Recommendation Report for Planning Permission

REF NO: AW/187/18/PL

LOCATION: Westside Cottage
254 Aldwick Road
Bognor Regis
PO21 3QH

PROPOSAL: Extension of garage to form single storey 1 bedroom residential unit for elderley relative & short term lets (resubmission following AW/50/17/PL). This application affects the setting of adjacent listed building.

WESTSIDE COTTAGE - DRAINAGE

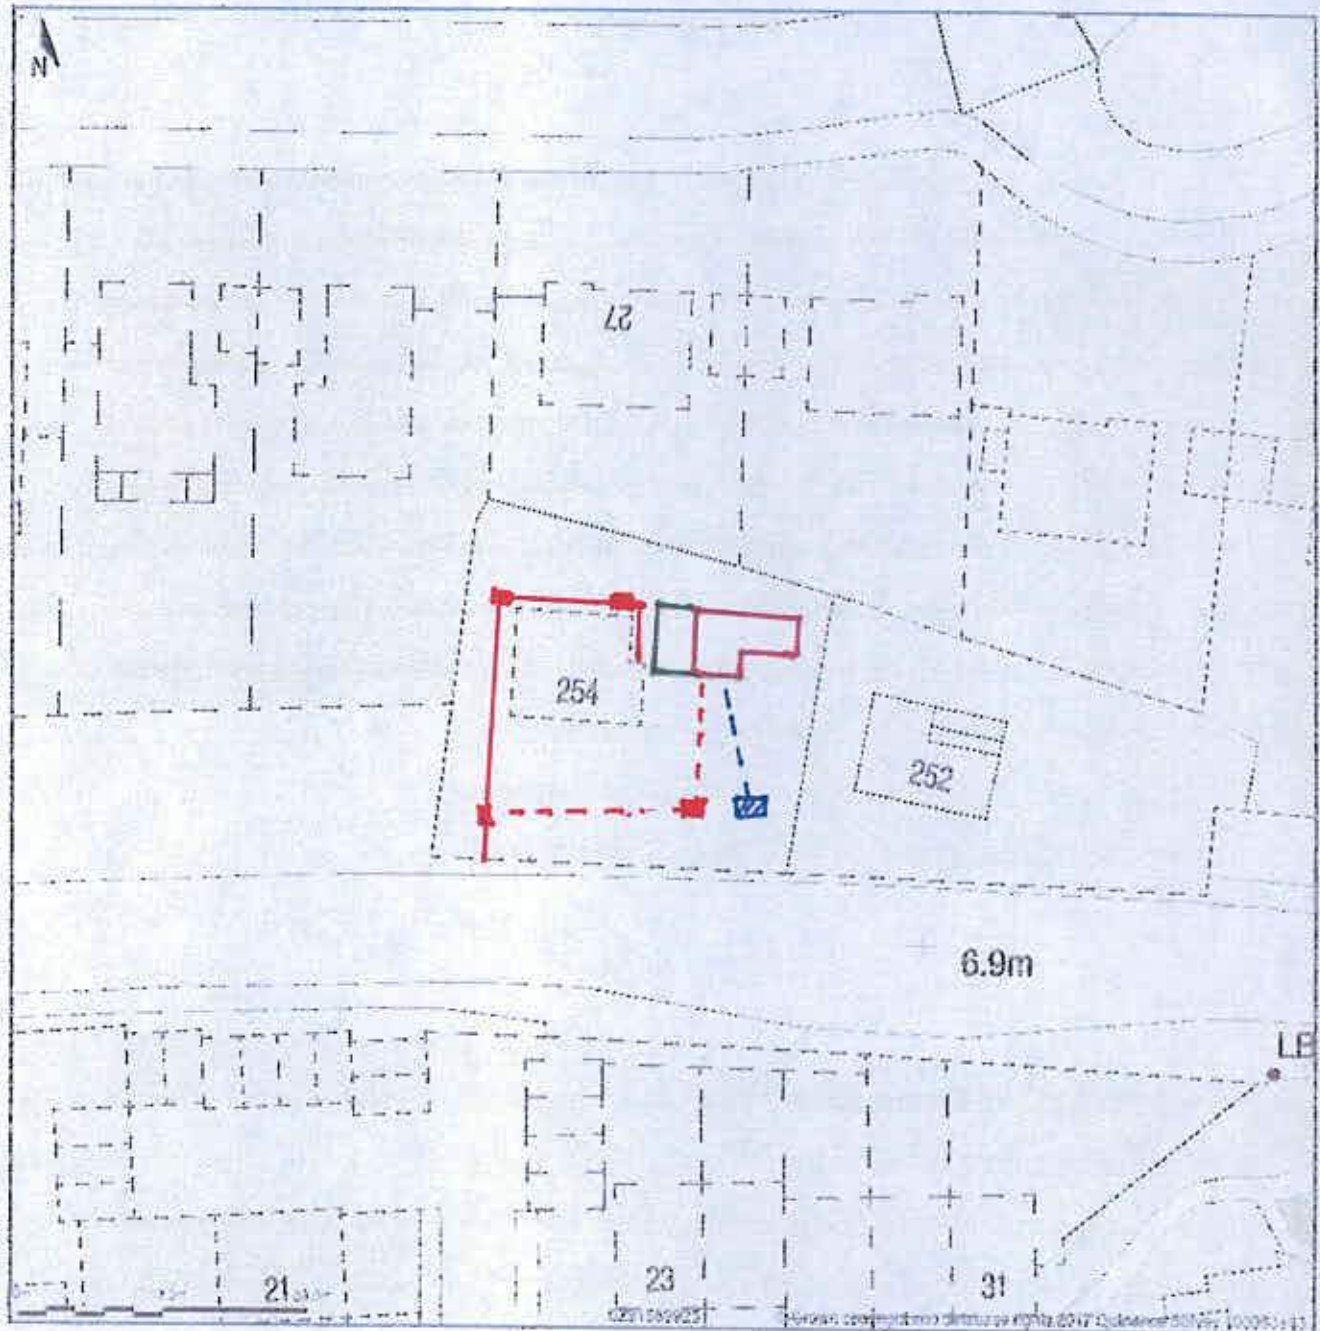
SOUTHERN WATER - Require an informative re new sewer connections. Also note that the site could be crossed by a sewer now deemed to be public.

- 7 INFORMATIVE: A formal application for connection to the public sewerage system is required in order to service this development, please contact Southern Water, Sparrowgrove House, Sparrowgrove, Otterbourne, Hampshire SO21 2SW (Tel: 0330 303 0119) or www.southernwater.co.uk. Please read our New Connections Services Charging Arrangements documents which has now been published and is available to read on our website via the following link <https://beta.southernwater.co.uk/infrastructurecharges>.

1. ELEVATIONS

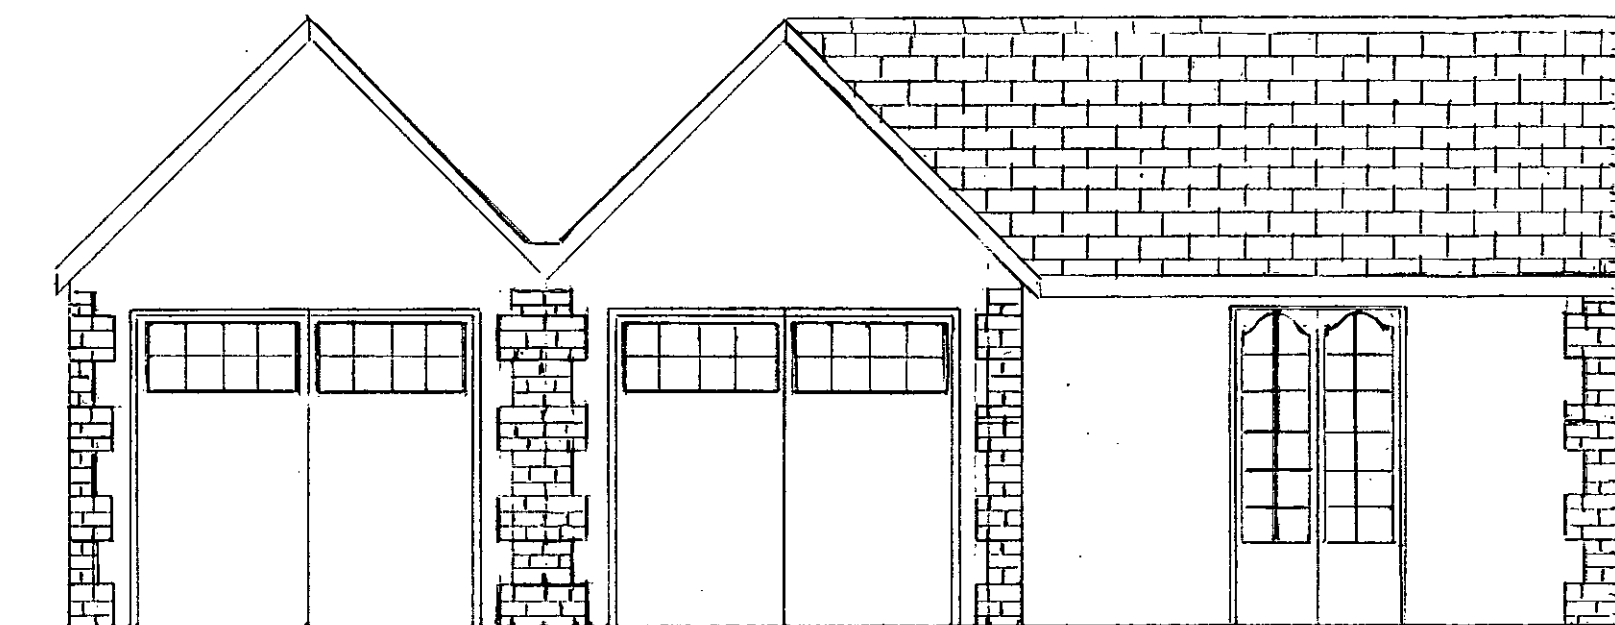
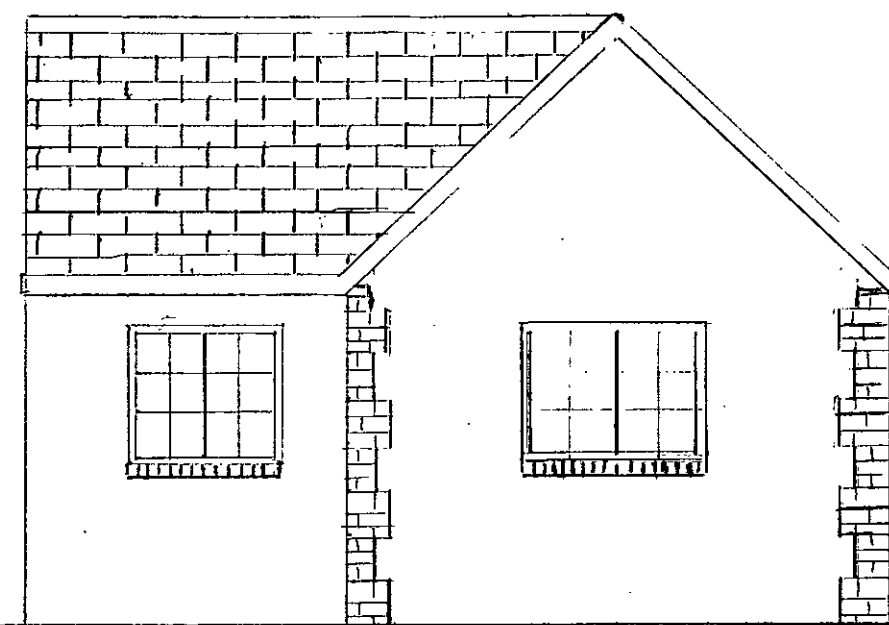
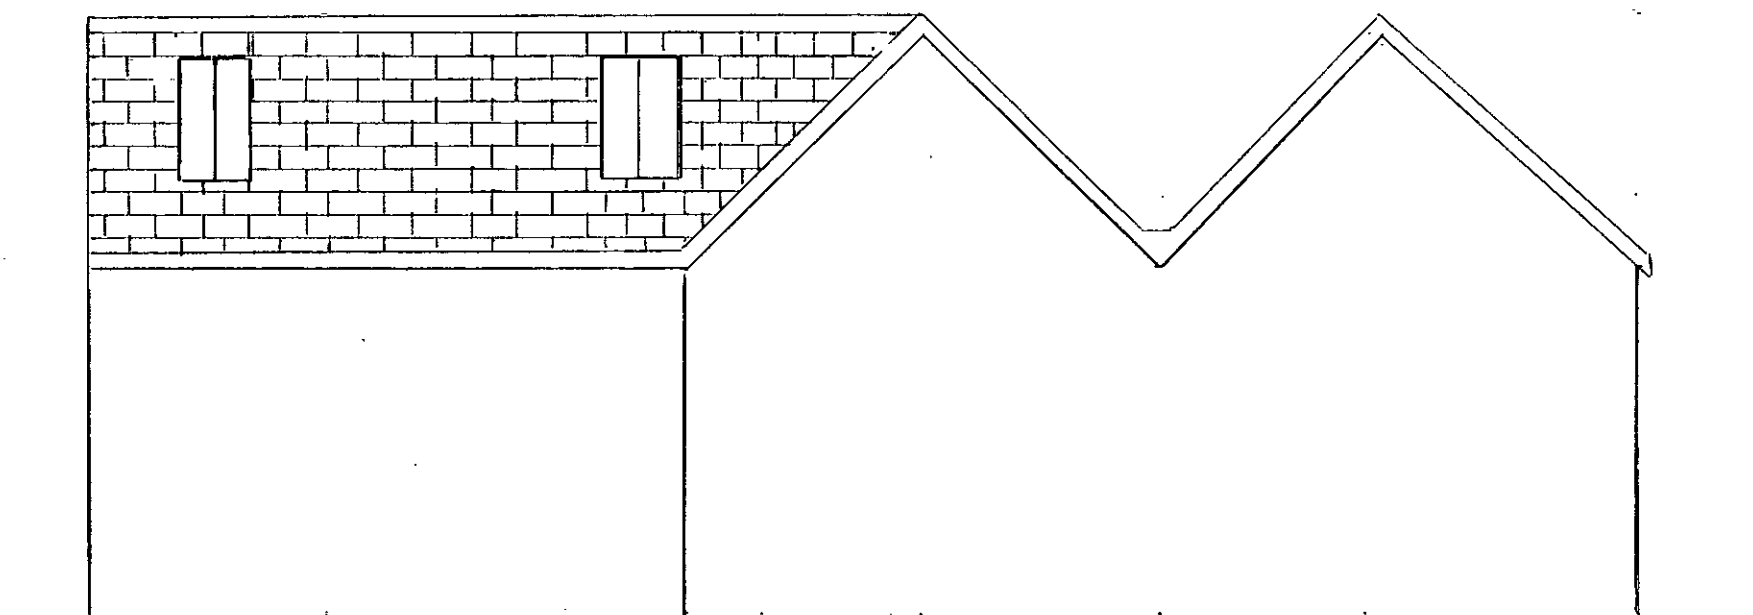
DESCRIPTION OF APPLICATION	As above. The extension on the eastern side of the garage adds a bedroom, kitchen/lounge and a bathroom. The extension is to be no higher than the existing garage roof ridge and will be constructed in matching materials with part of the front elevation also resembling the doors to the adjacent garage.
SITE AREA	548m ² .
TOPOGRAPHY	Predominantly flat.
TREES	None affected by the proposed development.
BOUNDARY TREATMENT	- 1.8m high timber fencing enclosing the garden to the immediate east of the garage; - 1.8m high timber fencing to no. 252; - 2m high timber fencing to the rear northern boundary; and - Flint boundary wall to front.
SITE CHARACTERISTICS	Detached double fronted house. Roman cement to the front and flint to the side. Painted white. Two storey flat roof rear extension. Plastered walls. Detached single pitched roof garage to the side (Smooth white rendered bricks, red/brown in-rendered bricks & a tile roof). Gardens to front, rear and side.

The Council's Conservation Officer has assessed this application and considers that it is small scale & subservient to the main property. It is also considered that the proposal will maintain the appearance of the existing garage structure and have very limited visibility from the street-scene or either listed building. The conclusion is that the impact is neutral on heritage assets is neutral

- 3 No development above damp proof course (DPC) level shall take place unless and until a schedule of materials and finishes and samples of such materials and finishes to be used for external walls and roofs of the proposed extension have been submitted to and approved by the Local Planning Authority and the materials so approved shall be used in the construction of the extension.

- 4 No part of the new accommodation shall be occupied unless and until details of the construction and materials of all new joinery (windows & doors) have been submitted to and approved by the Local Planning Authority and the new joinery so approved shall be constructed in accordance with approved details.
